**KIRKLEES METROPOLITAN COUNCIL
INVESTMENT & REGENERATION SERVICE**

DELEGATED DECISION TO DETERMINE PLANNING APPLICATIONS

Reference No:	2025/62/93528/E
Site Address:	80, Marsh Lane, Shepley, Huddersfield, HD8 8AS
Description:	Demolition of existing dwelling and annex and erection of 3 detached dwellings with associated access and parking (for 3 self build/custom build dwellings)
Recommending Officer:	Danielle Cooper

DECISION – Refused

Development Proposals

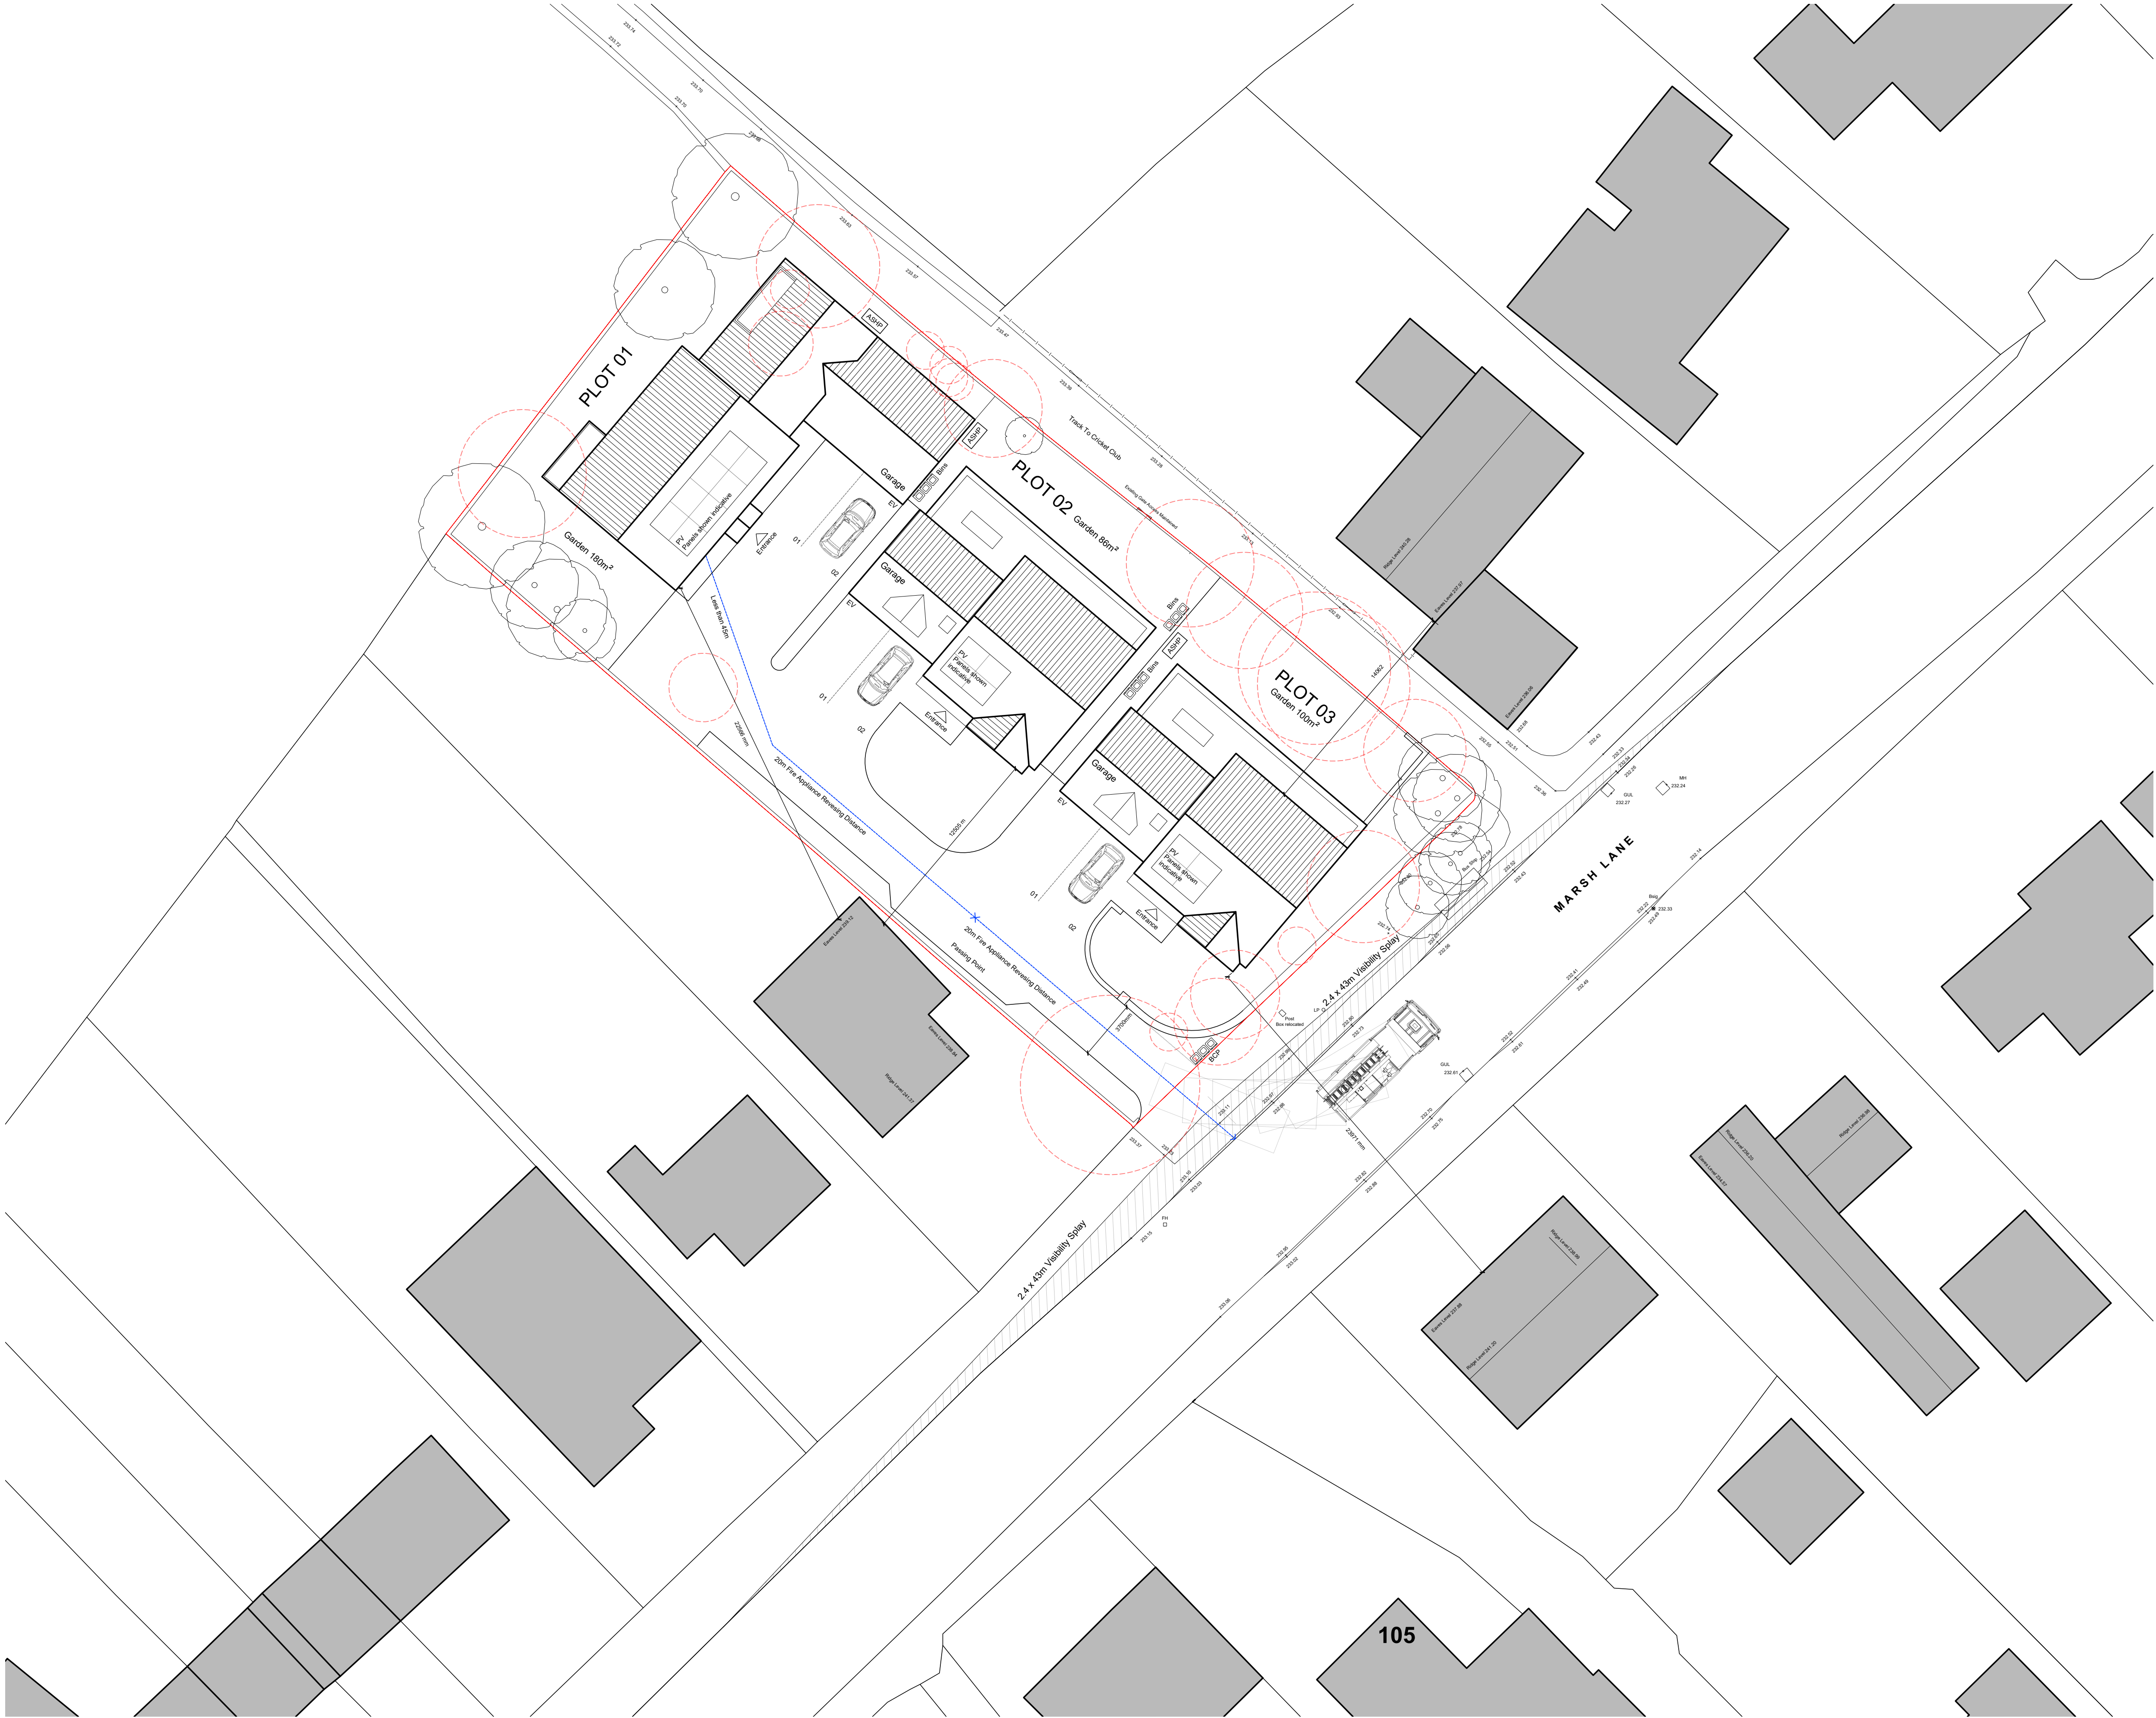
The proposed siting and layout of the proposed dwellings are considered unacceptable as the scheme does not sufficiently respond to the established spatial character, urban grain, or functional relationships within the surrounding area. As a result, the development appears incongruous within its context.

Plot 3 is also considered to project forward of the established building line along Marsh Lane, particularly when viewed in relation to the dwellings to the south-west. As a result, it would appear unduly prominent within the street scene, particularly when passing the site south to north. While it is acknowledged that the adjacent property to the north includes a single-storey garage that sits forward of the main building line, the principal elevations of dwellings along this section do not, and therefore this feature is afforded limited weight in justifying the proposed encroachment.

As previously outlined, the prevailing character along Marsh Lane is defined by dwellings that present their principal elevation to the street. In contrast, Plot 3 would not front Marsh Lane, with its side elevation addressing the street. This arrangement disrupts the established pattern of principal elevations facing the highway and fails to respect the existing urban grain. To have a side wall facing onto the street would act to diminish the established street pattern and character of the area, further adding to the adverse affect of the development on the character of the area.

The proposal to accommodate three large detached dwellings across the width of the site is considered to result in a cramped and overly intensive form of development. Policy LP7 of the Kirklees Local Plan sets a target density of thirty-five dwellings per hectare, and on that basis the site could theoretically support a higher number of units. However, the immediate context along the northern side of Marsh Lane is characterised by single dwellings set within generous plots, giving the area a distinctly spacious and low-density character. Furthermore, Paragraph 7.19 of Principle 6 of the Housebuilders Design Guide SPD states that for dwellings of two storeys or more, a minimum separation of 2m should normally be maintained between the side elevation and the shared boundary. The proposed dwellings generally do not achieve this distance. When combined with their scale, massing, and siting,

In addition, the extent of hardstanding proposed along the southern boundary is considered excessive. It would appear visually dominant within the street scene and in turn significantly limit opportunities for meaningful soft landscaping, further contributing to the perception of overdevelopment.

KC Trees have also noted that there has been damage to the roots of existing trees. It is noted that there is limited space between Plot 1 and trees T1 and T2. The Arboricultural Impact Assessment Plan, dated 20/12/2025, also shows no working space available between Plot 1 and the tree protection fencing (TPF) surrounding T1 and T2. This is likely impracticable and could result in the TPF being removed during construction. This would create a foreseeable opportunity for accidental damage to occur to T1 and T2.

KC Trees have therefore objected and have stated that any proposed buildings should be adequately set back from retained trees to avoid foreseeable issues from developing in the future.
